Consultation Response from KC, Conservation and Design

2021/93305 61-65, New Street, Huddersfield, HD1 2BQ

Change of use and conversion of existing buildings, forming split-level six storey development comprising four-storey stairwell, four-storey roof-top tower block and enclosed courtyard to create 25 dwellings and sub-division of the retail unit forming 61-63 New Street (Full Application)

Date Responded: 20 July 2023

PROPOSED ELEVATIONS SHEET 1

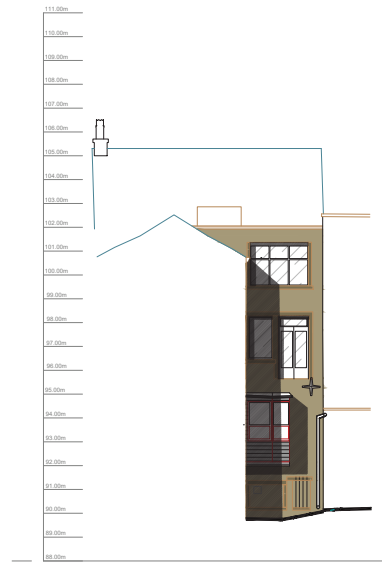
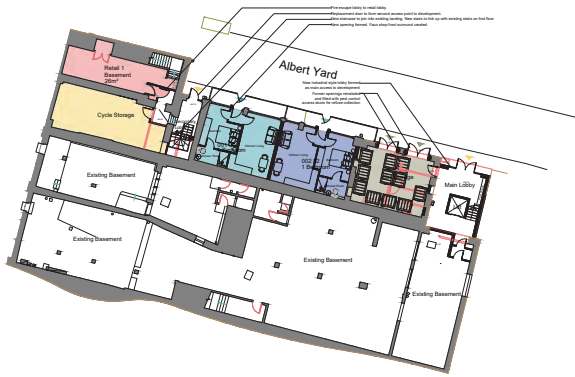
Following discussions, the proposal has been amended to either repair the windows on the north elevation facing Albert Yard or replace them to match the existing. A window schedule submitted with drawing 2655(100)20B shows the windows on the top two floors retained, with glazed panels inserted into the loading doors so that the legibility of the building as a former warehouse can be understood.

TYPICAL TOWER WINDOW DETAIL 1:20

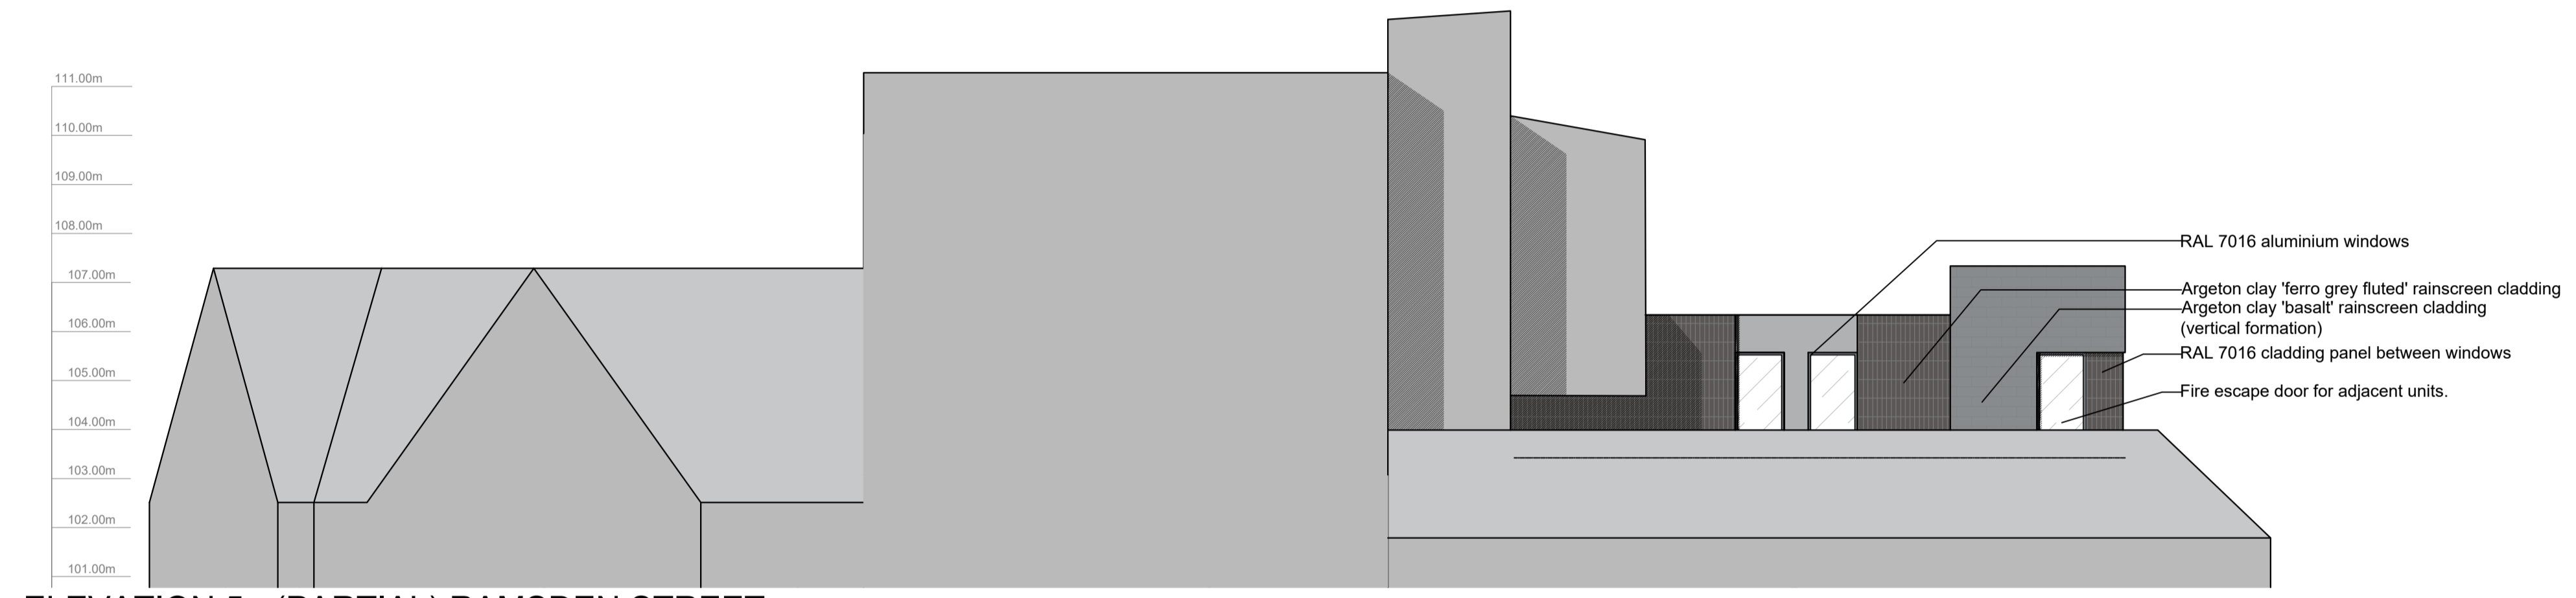
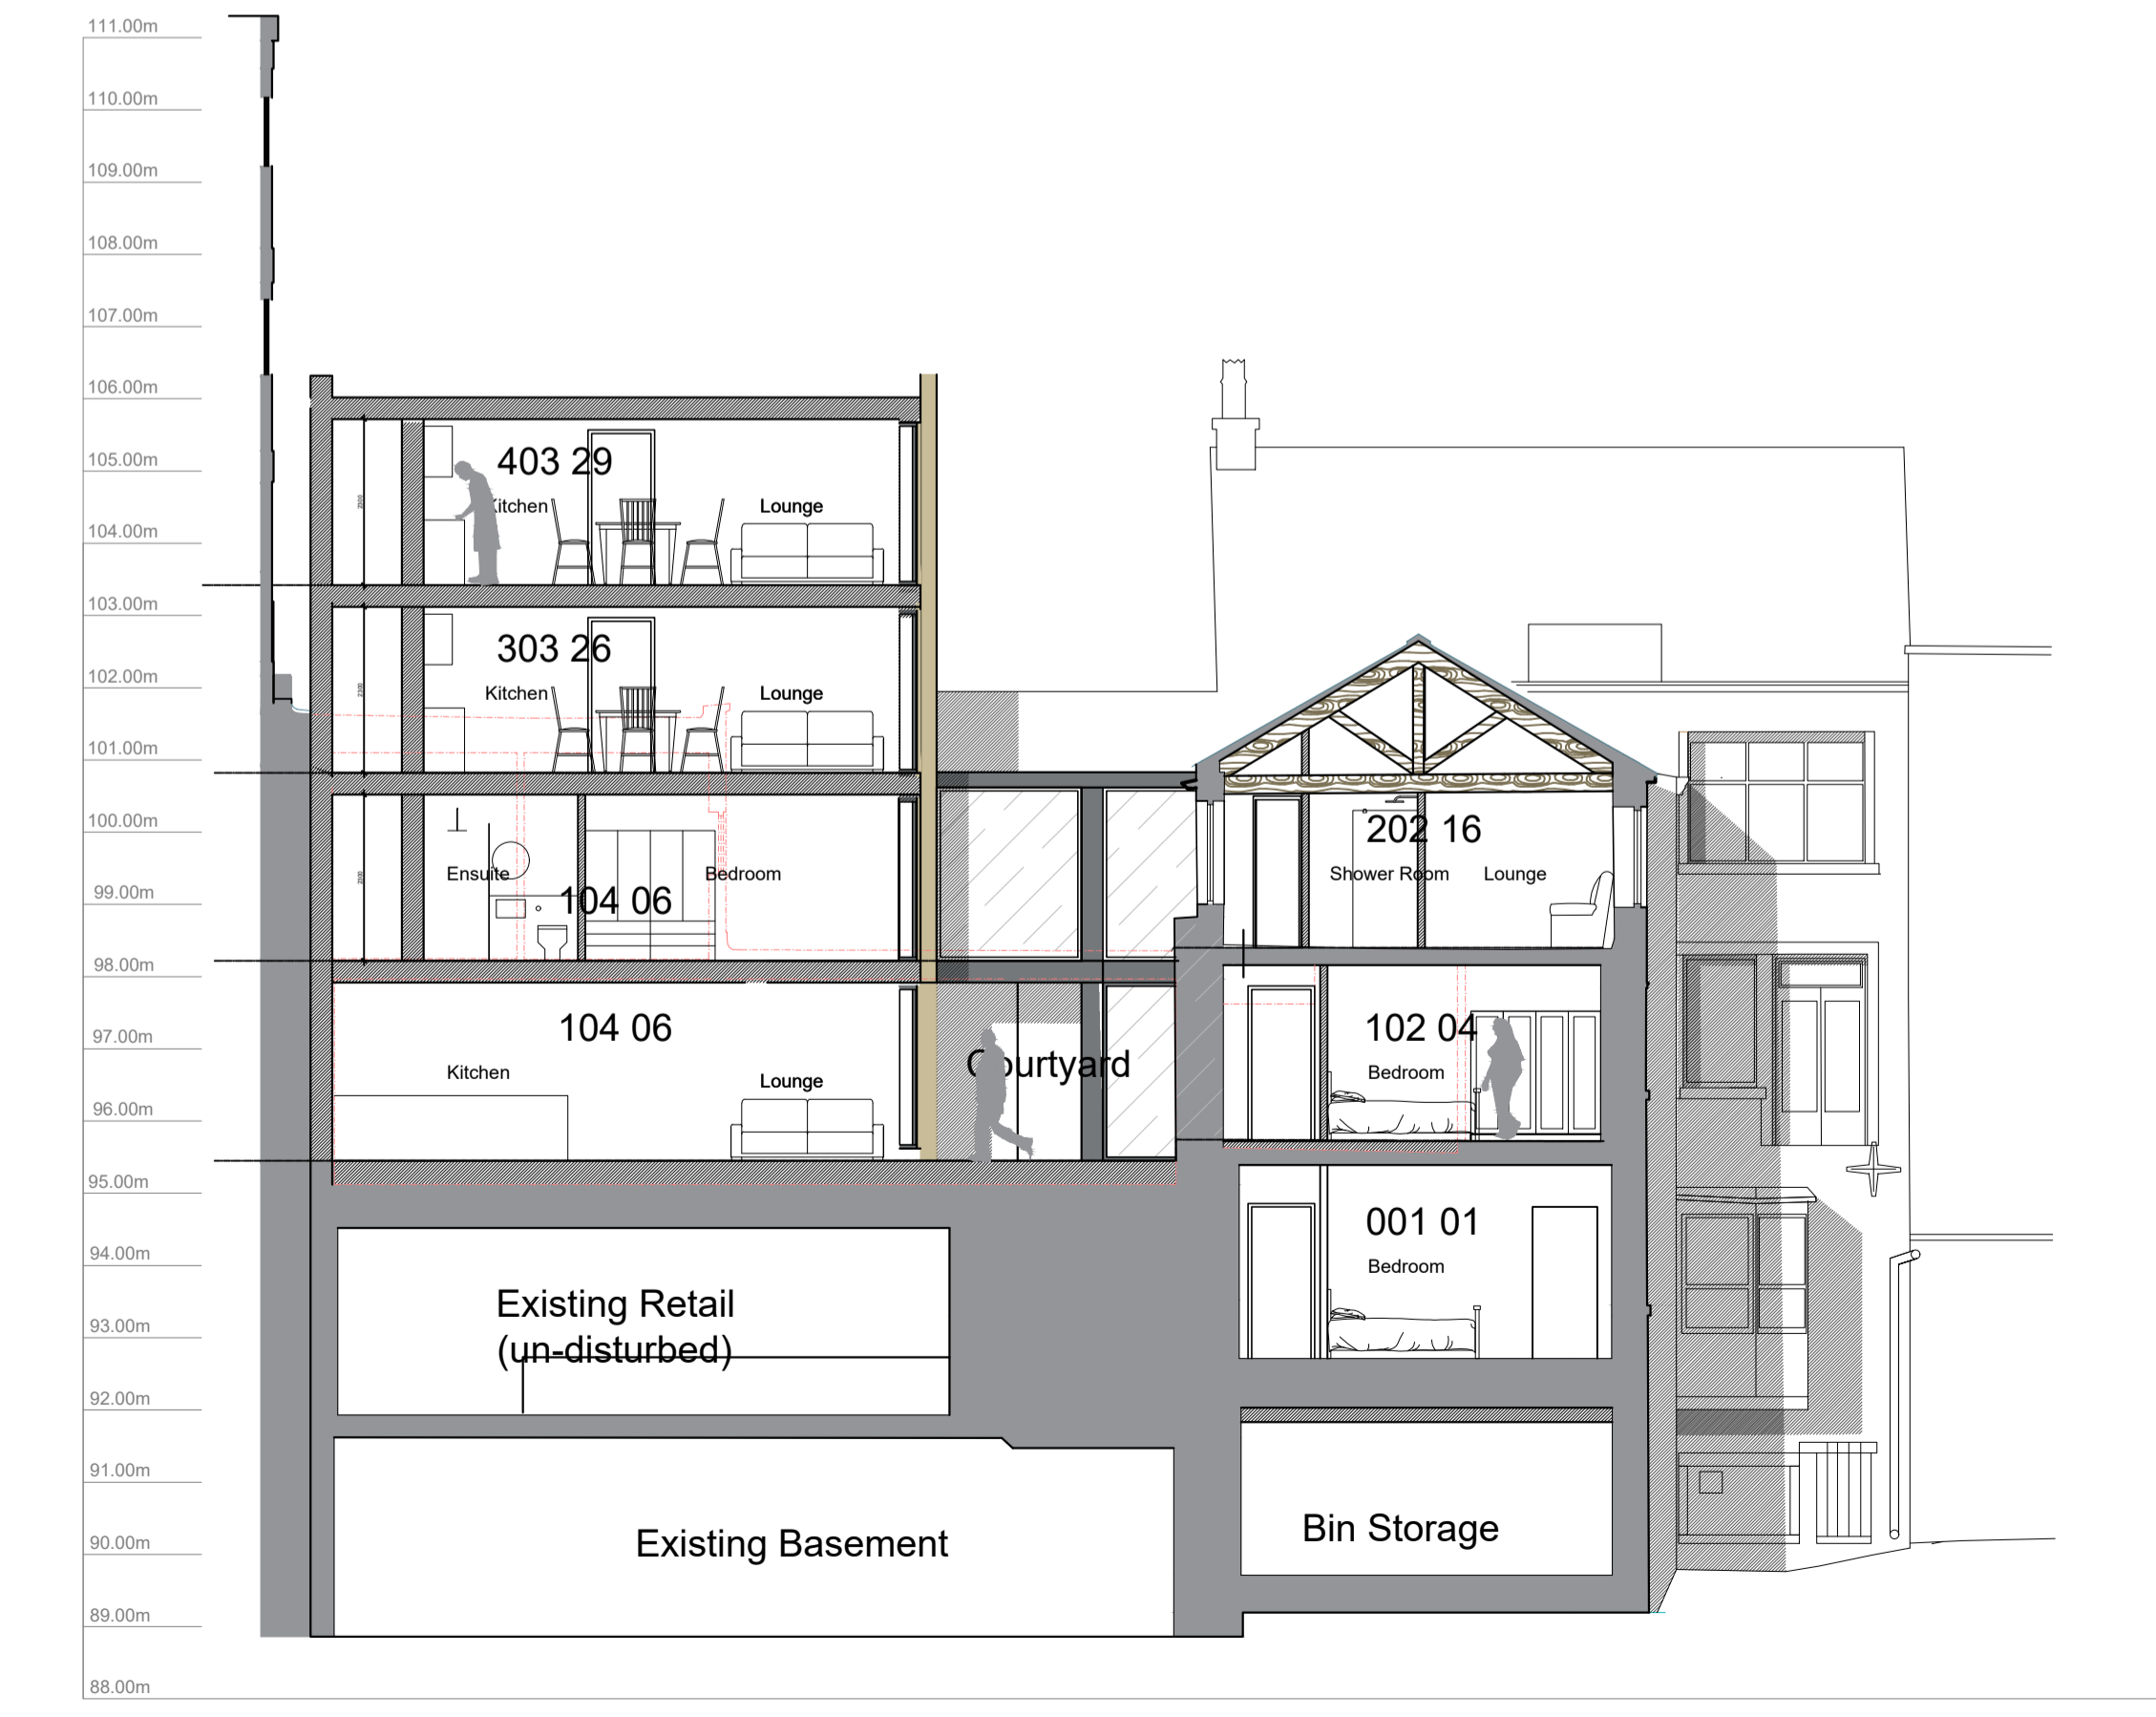
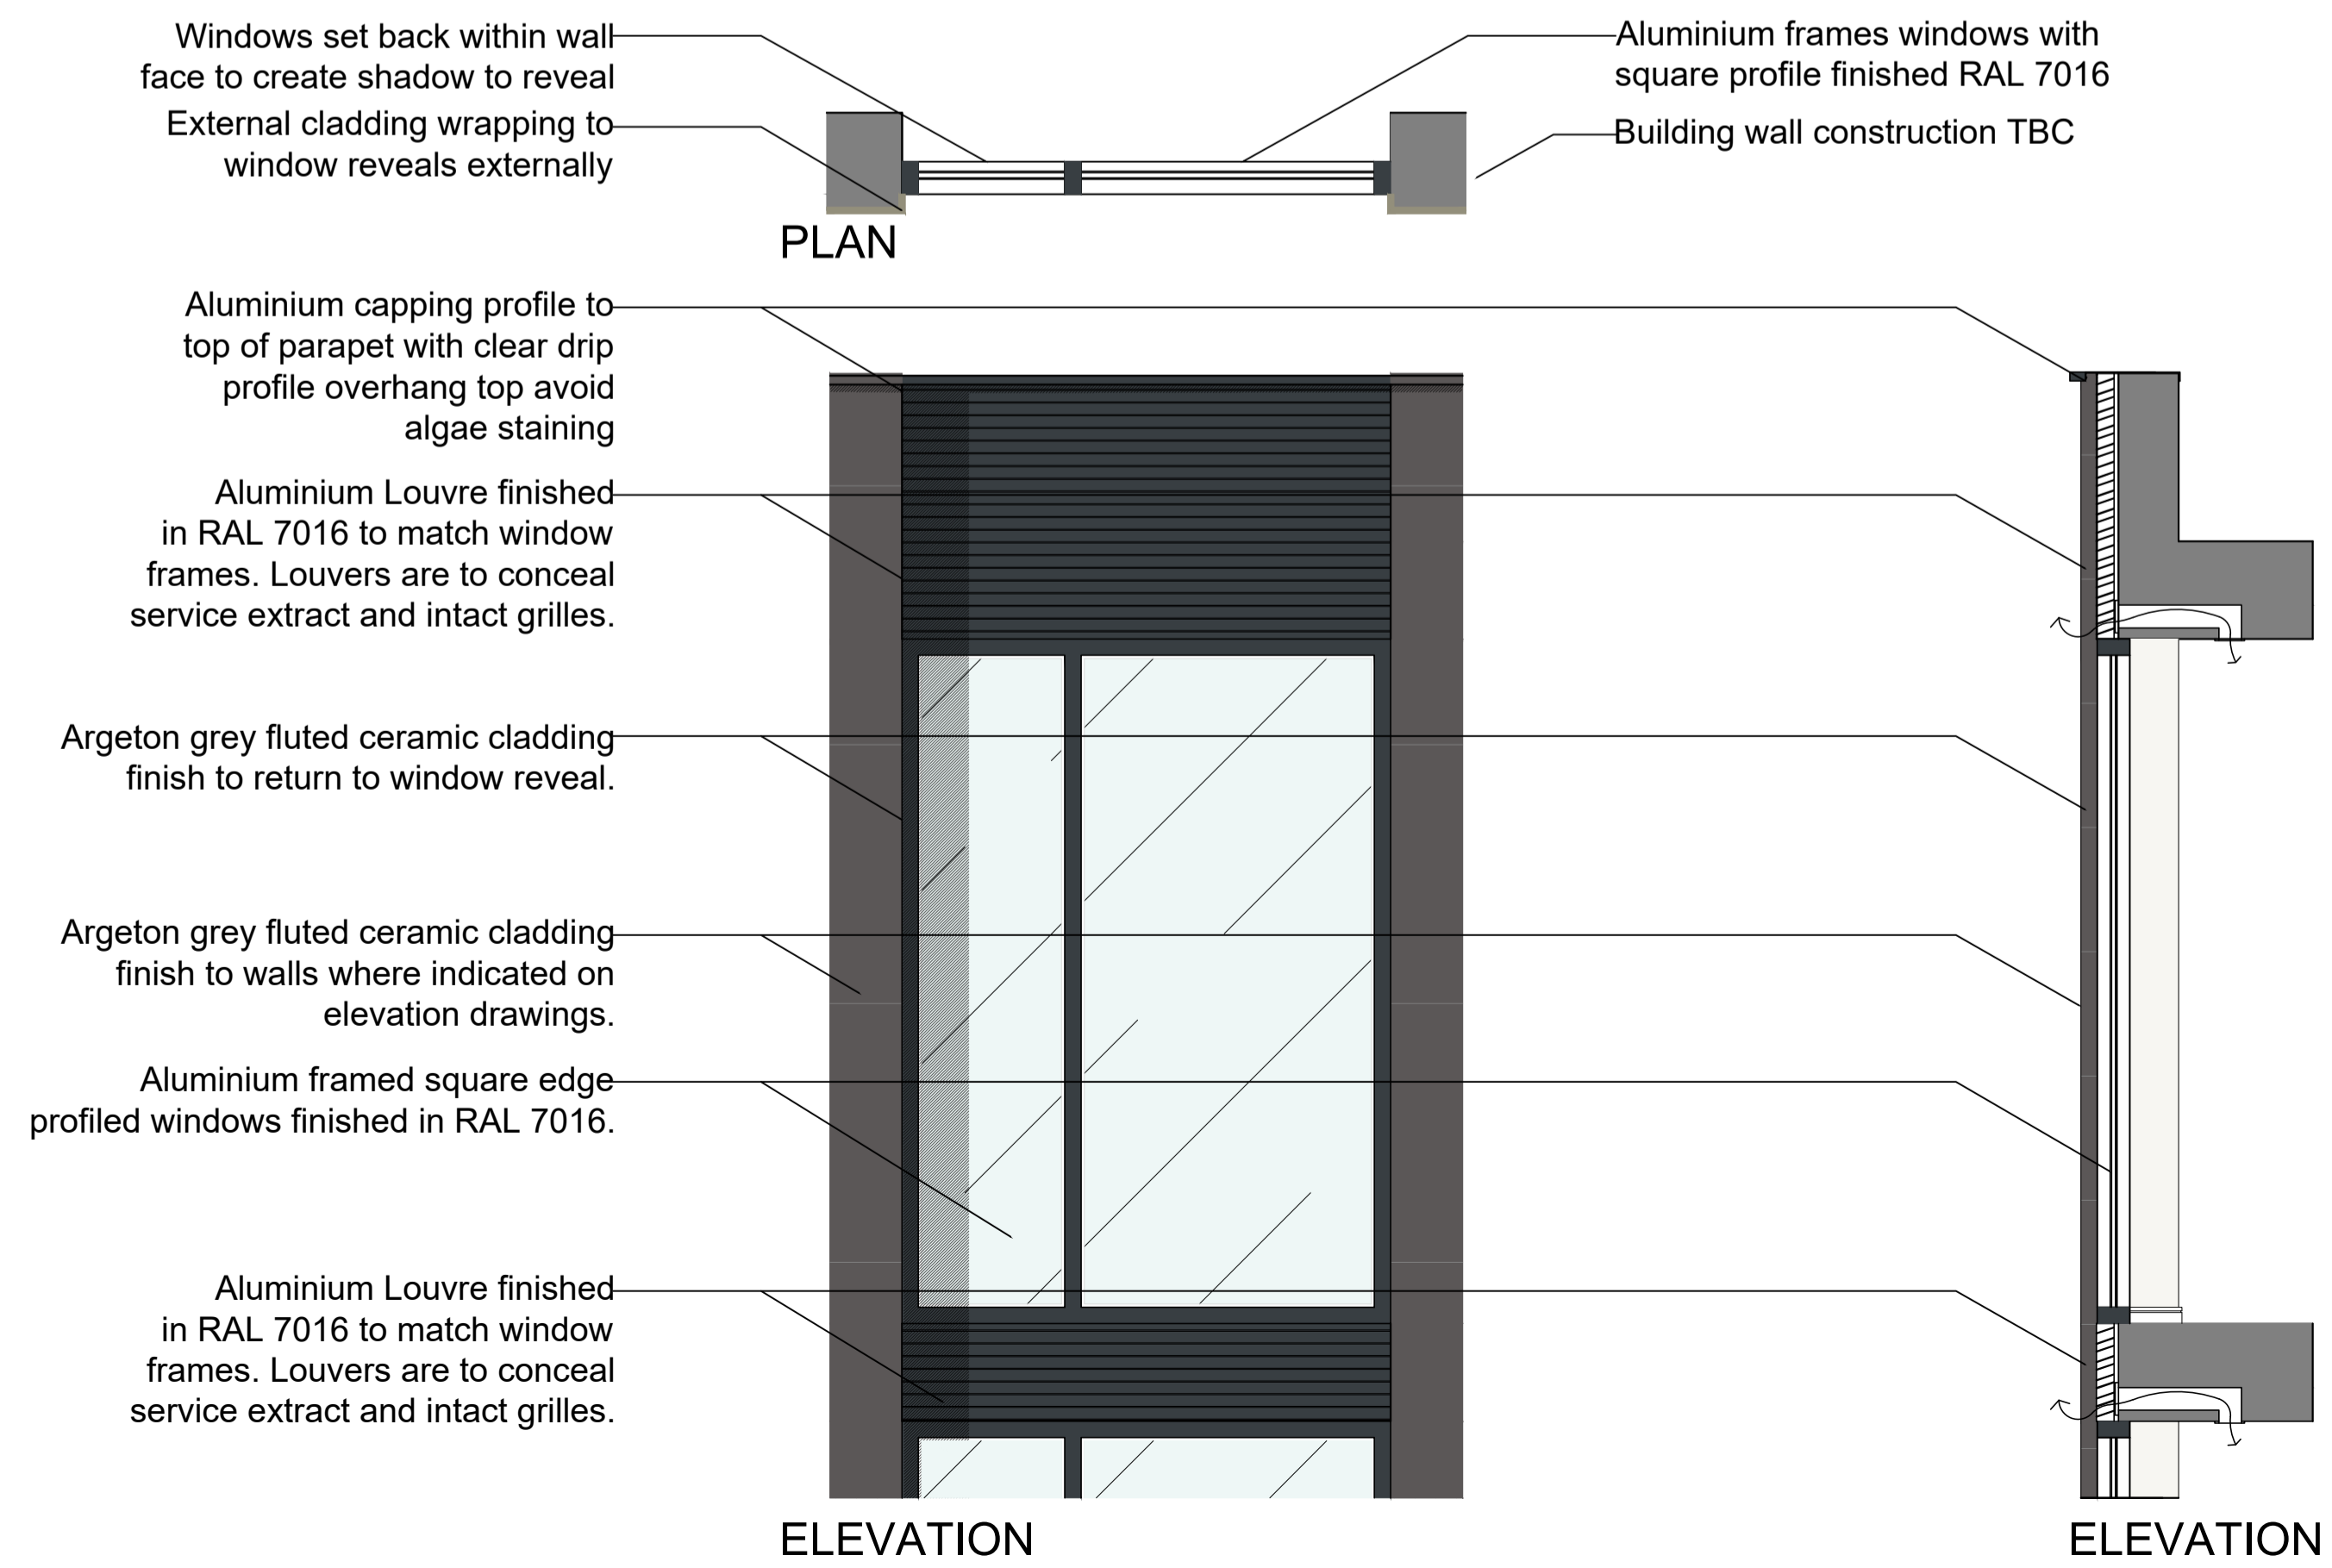
The cladding material has been clarified as Argeton ceramic tiles (iron grey fluted) with some articulation, with a feature wrap around element of contrasting colour introduced to the south-west corner to add visual interest when viewed from the new Cultural Heart development. The revised proportions are an enhancement, and the proposed dark cladding reflects the colour of the pitched slate roofs within the vicinity. We would recommend that external materials are submitted for approval and a condition is recommended below.

- Details of render type, colour and texture to be submitted for approval along with a sample panel.
- External material samples shall be submitted for approval.
